Rosefield Solar Farm – Deadline 6

CSAG Response to Applicant's Position Paper on Arable Field Margins and Hedgerow Mapping [REP5-094] and CSAG comments on Applicant's latest revised BNG Metric calculation [REP5-056] and BNG Assessment [REP5-058]

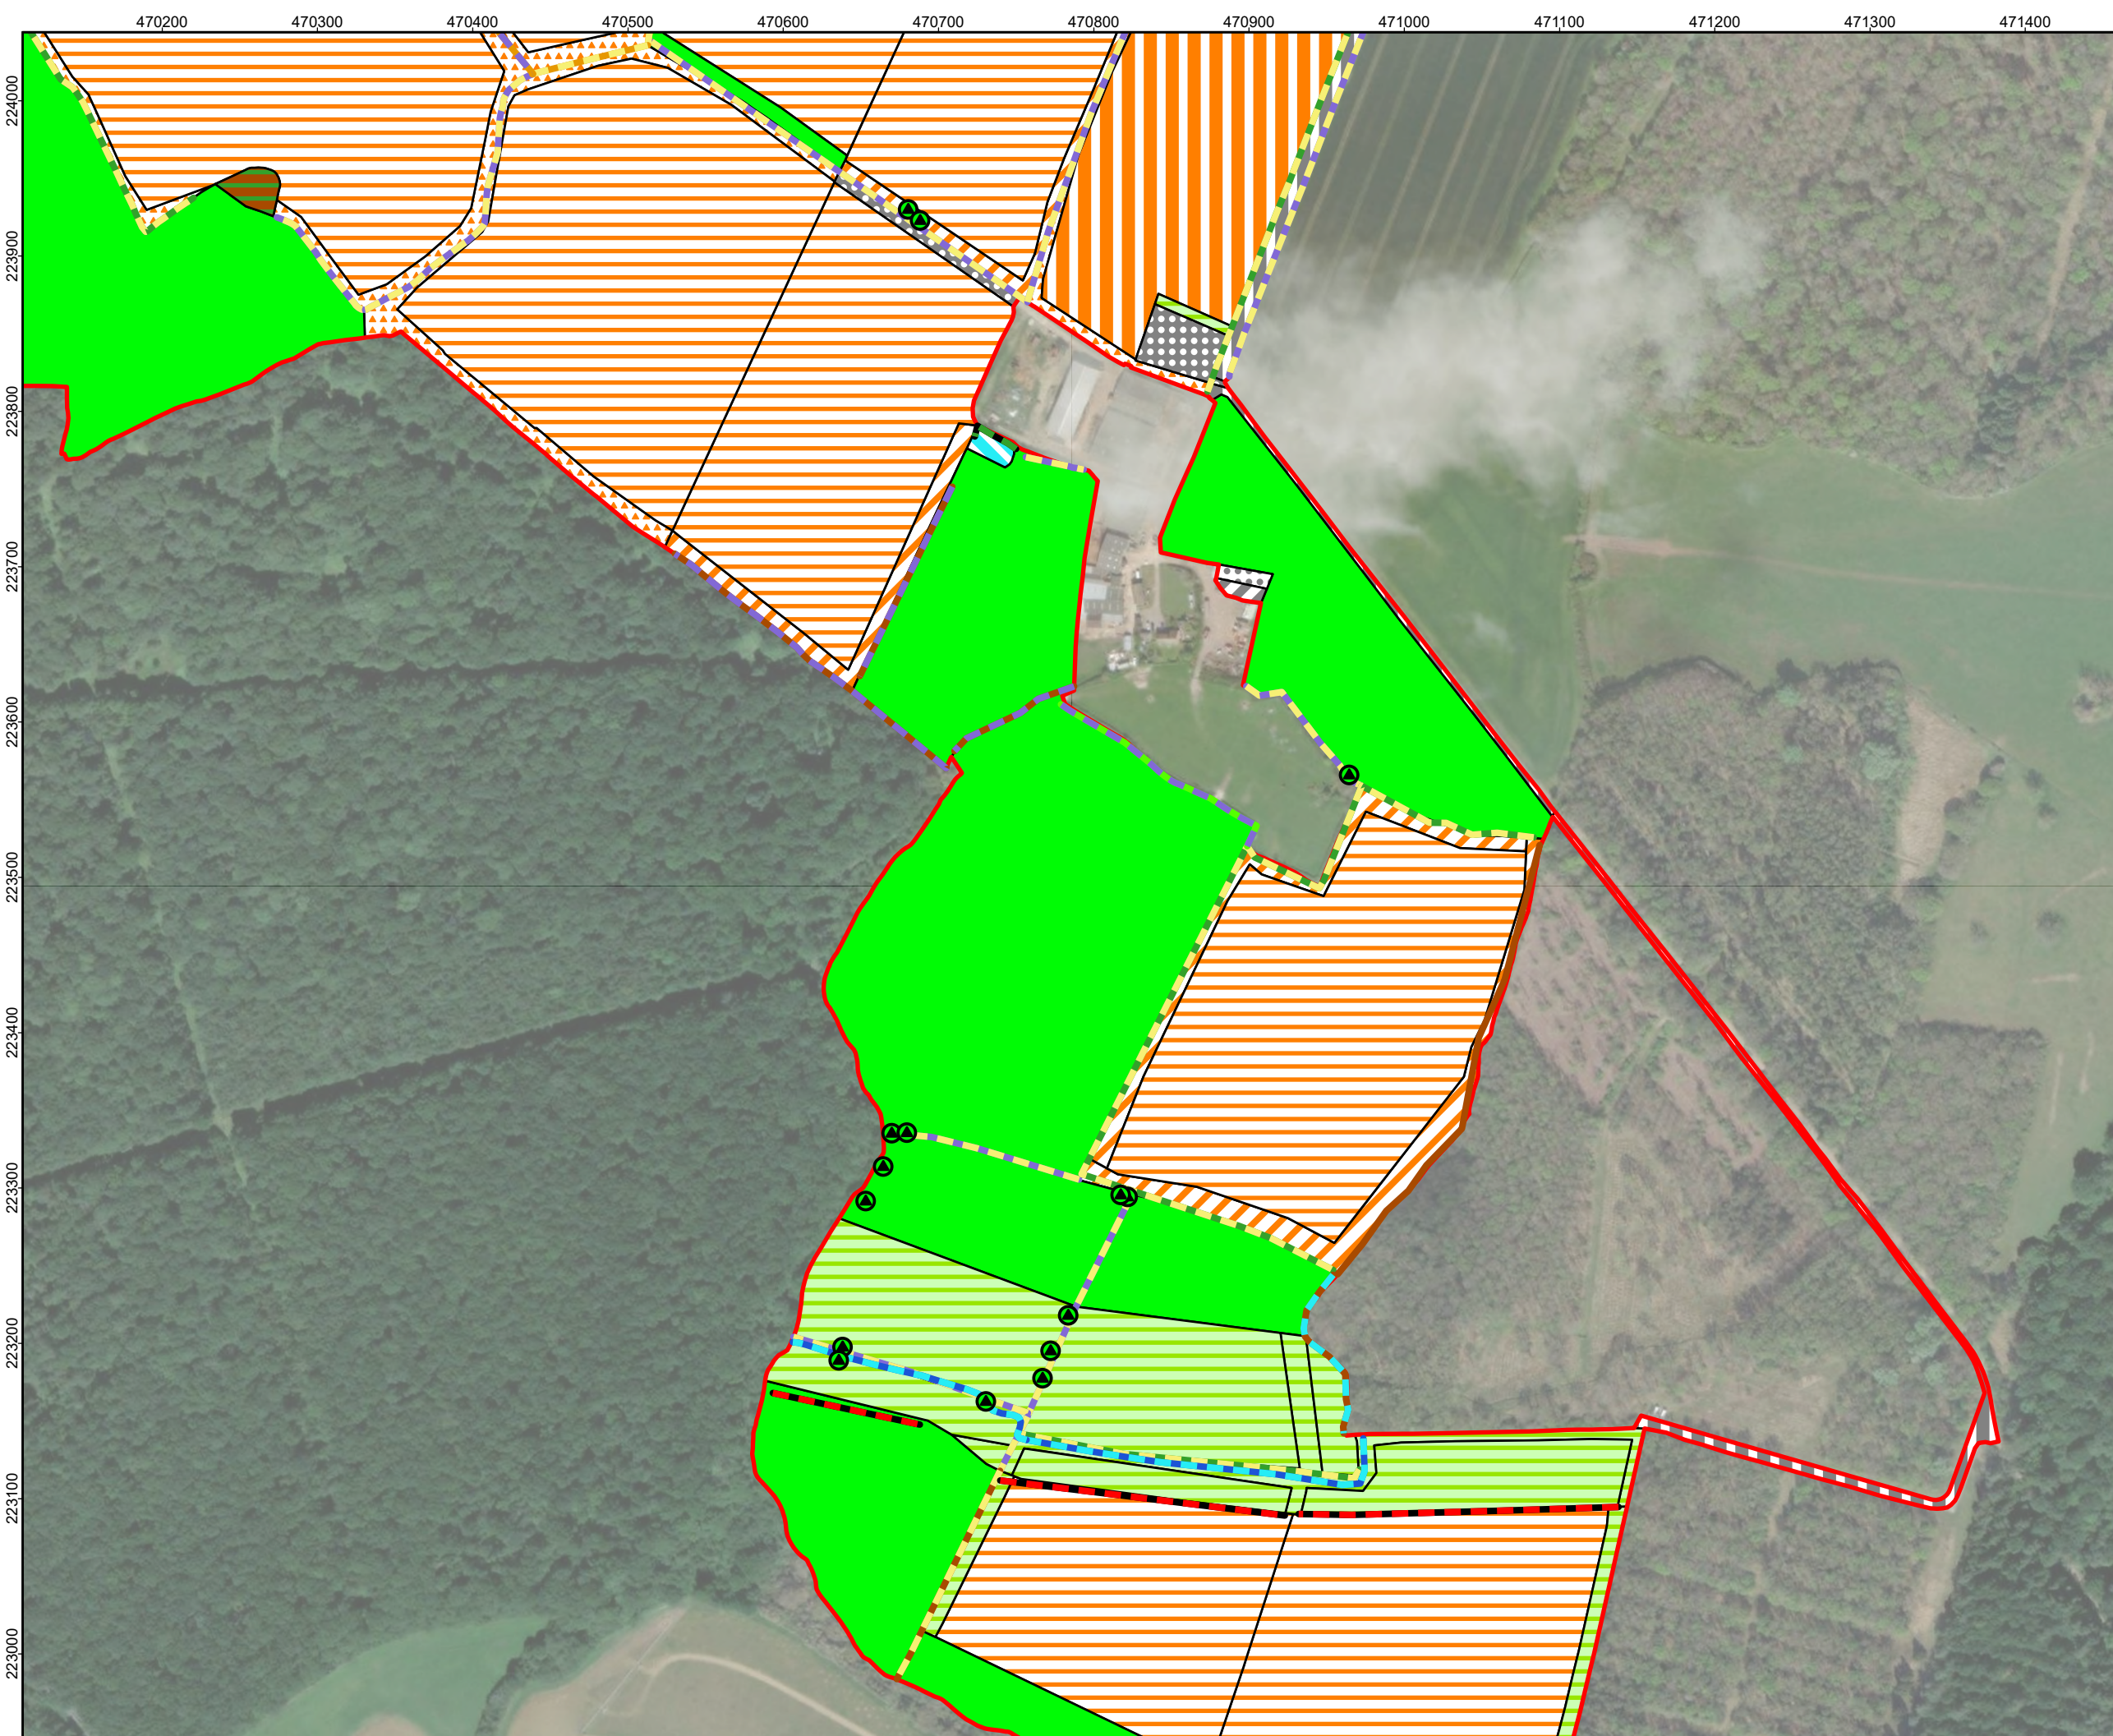
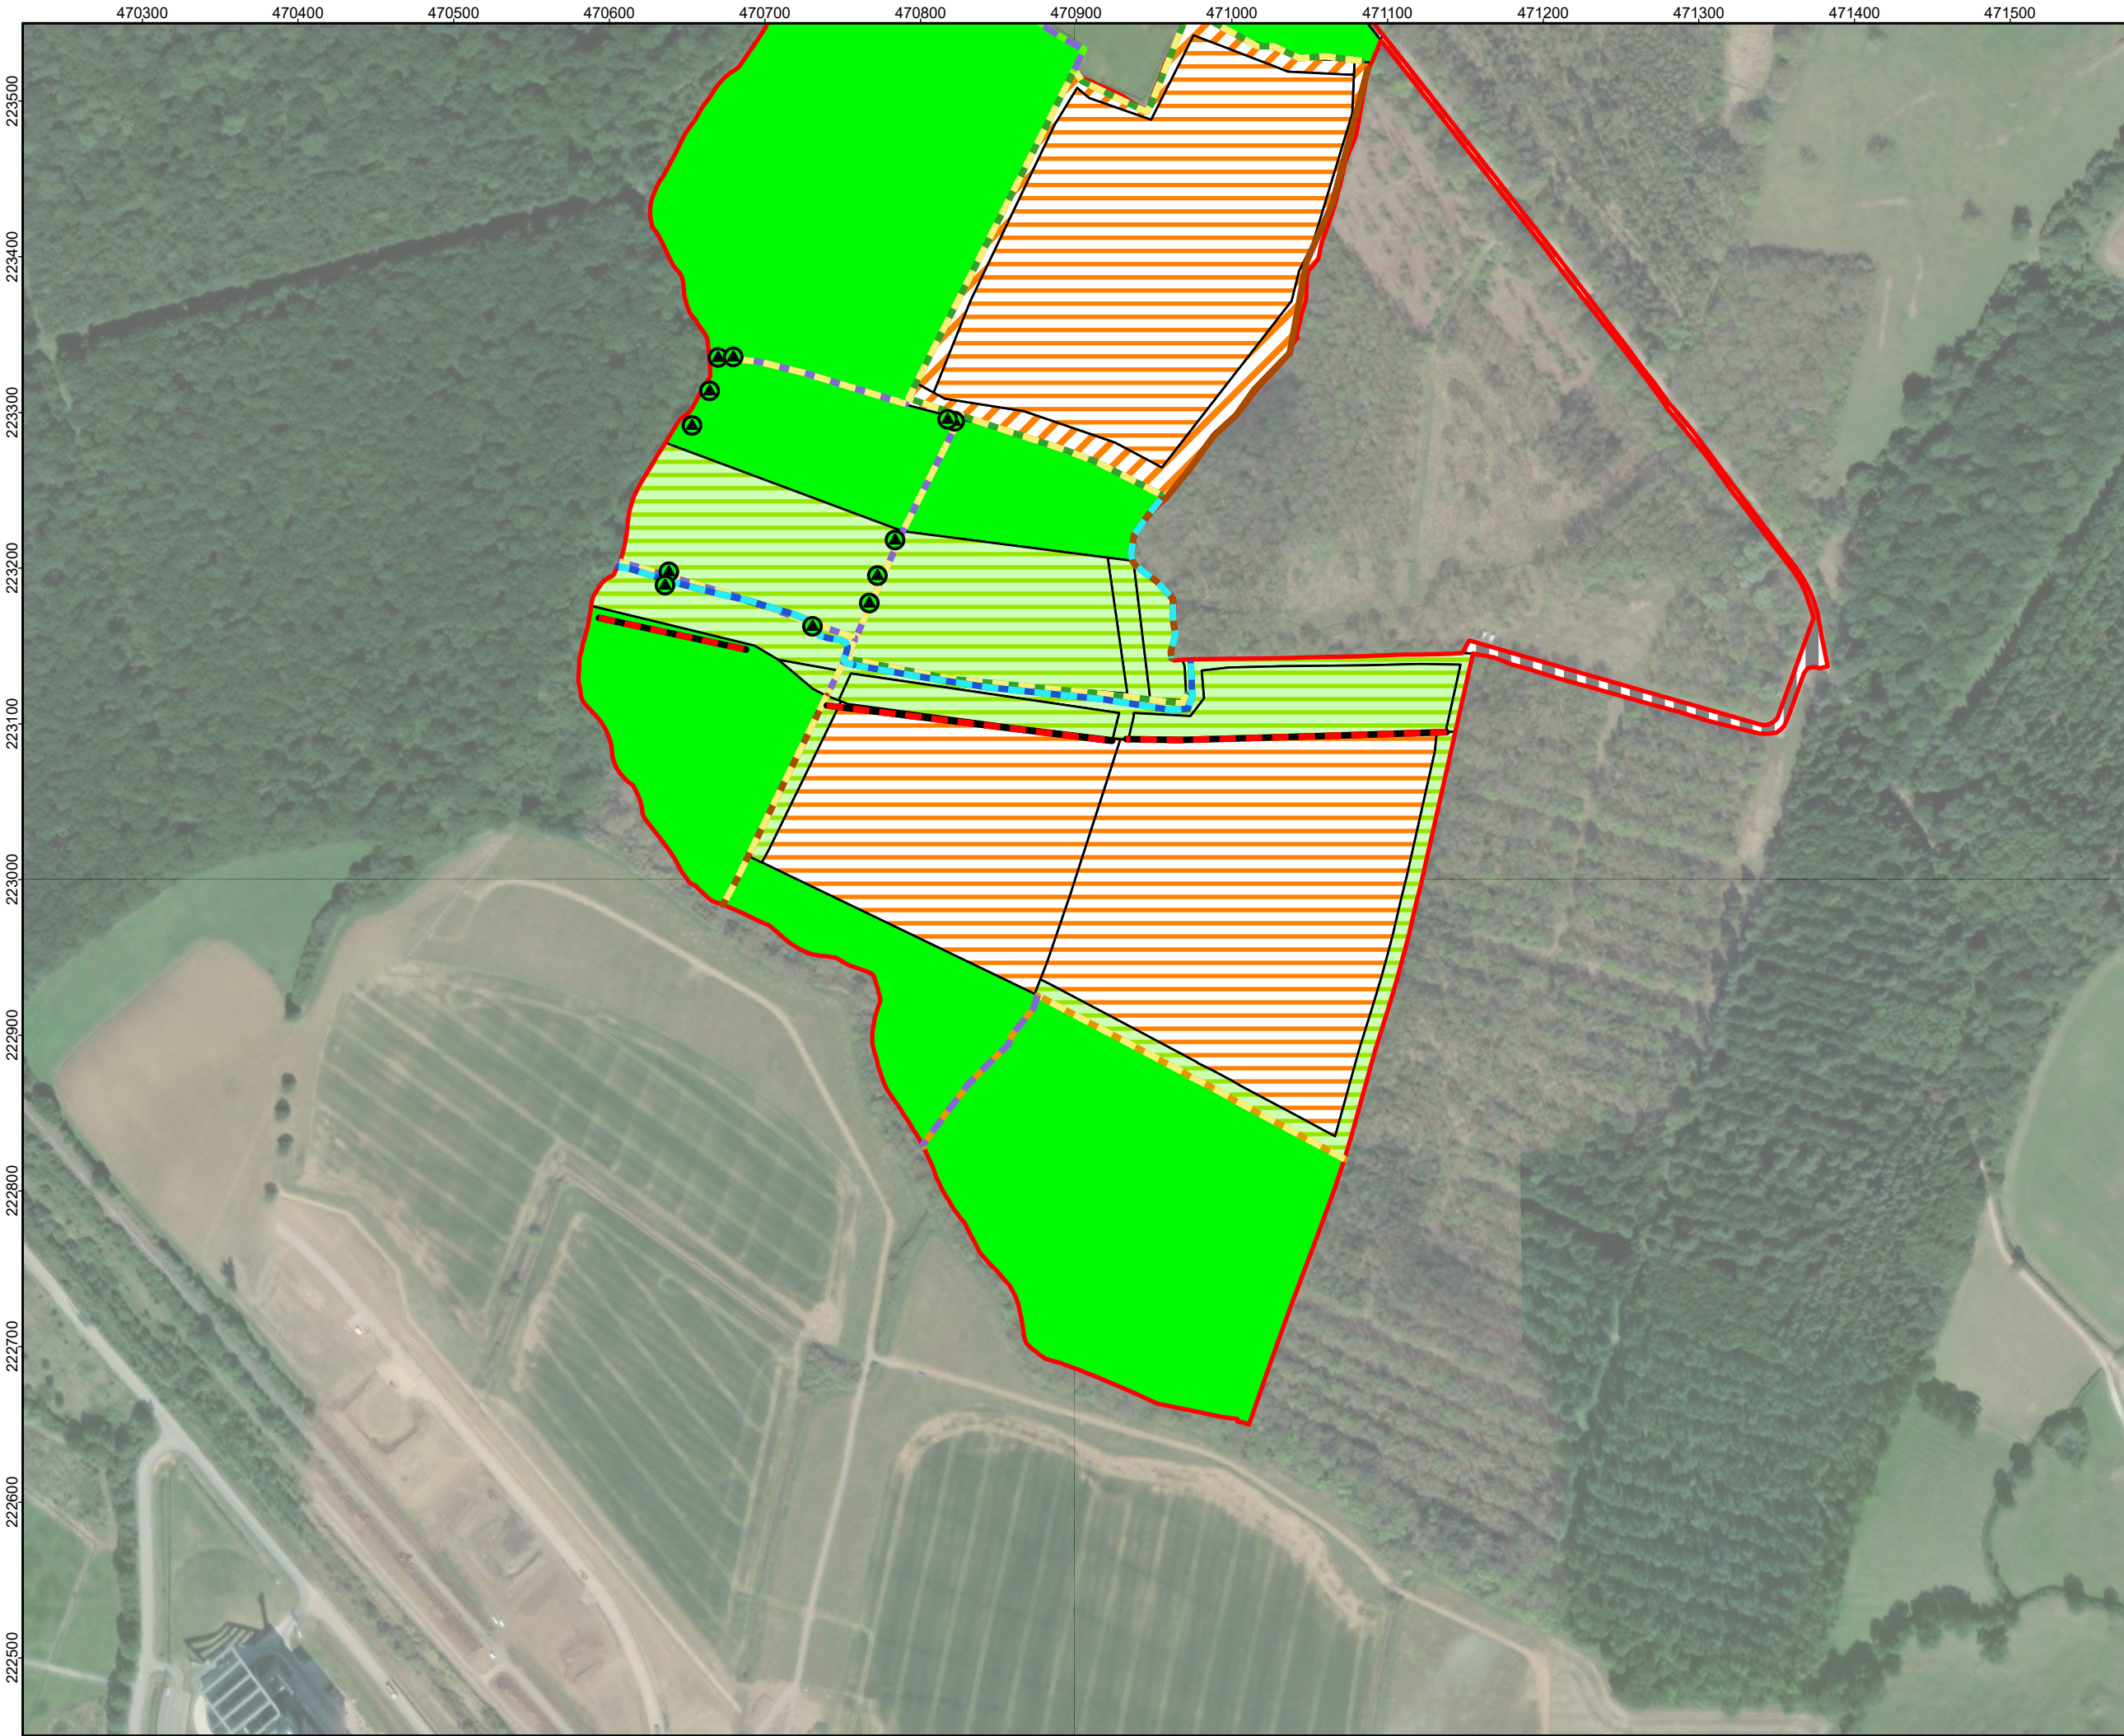
- 2.1 The Position Paper defends the Applicant's approach to classification of habitats at narrower field margins and beneath hedgerows as 'cropland' via a misinterpretation of the Statutory Metric User Guide requirement that habitats should be mapped 'to the centre line of the hedgerow'. The premise that habitat mapping should extend to the centreline of any hedgerow is not, and never has been, the substance of the dispute. It is of course the case that no areas of the site should be left as blank or white land – i.e. unmapped, unclassified and unscored. CSAG have never contested otherwise.
- 2.2 The question of concern to CSAG is about how habitats within two metres of, and extending beneath, hedgerows (especially where adjoining active arable land), once mapped, are then classified and scored, not whether they should be mapped or not.

- 2.3 What the Applicant has done (and inexplicably seeks to continue to defend) is classify, map and score such areas and their non-cropland habitats simply as a continuation of the adjacent cropland. The Applicant continues to try and justify this approach in some instances by reference to the 'minimum mapping units' of the UKHab regime, but (presumably in recognition of the fact that the size of these areas logically exceeds any rational application of MMU in all instances) it seems to have retreated from that defence.

- 2.4 CSAG has consistently pointed out that classifying, mapping and scoring land at arable field margins and extending beneath hedgerows as a continuation of the adjacent cropland is not only (and indisputably) wrong as a matter of fact and on the ground, but the approach of classifying and scoring these strips of land as cropland also introduces two forms of error bias into the calculations, both of which unjustifiably elevate the output BNG score.

- 2.5 The first source of bias is that this approach has a suppressing effect on the baseline value of these areas in the BNG calculation (as cropland scores lower than unmanaged field margin grassland for example). The second is that it adds an unjustified additional uplift to the post-development score based on a conversion from low-scoring cropland to higher-scoring grassland, when such habitats are generally already grassland or ruderal habitat, not cropland.
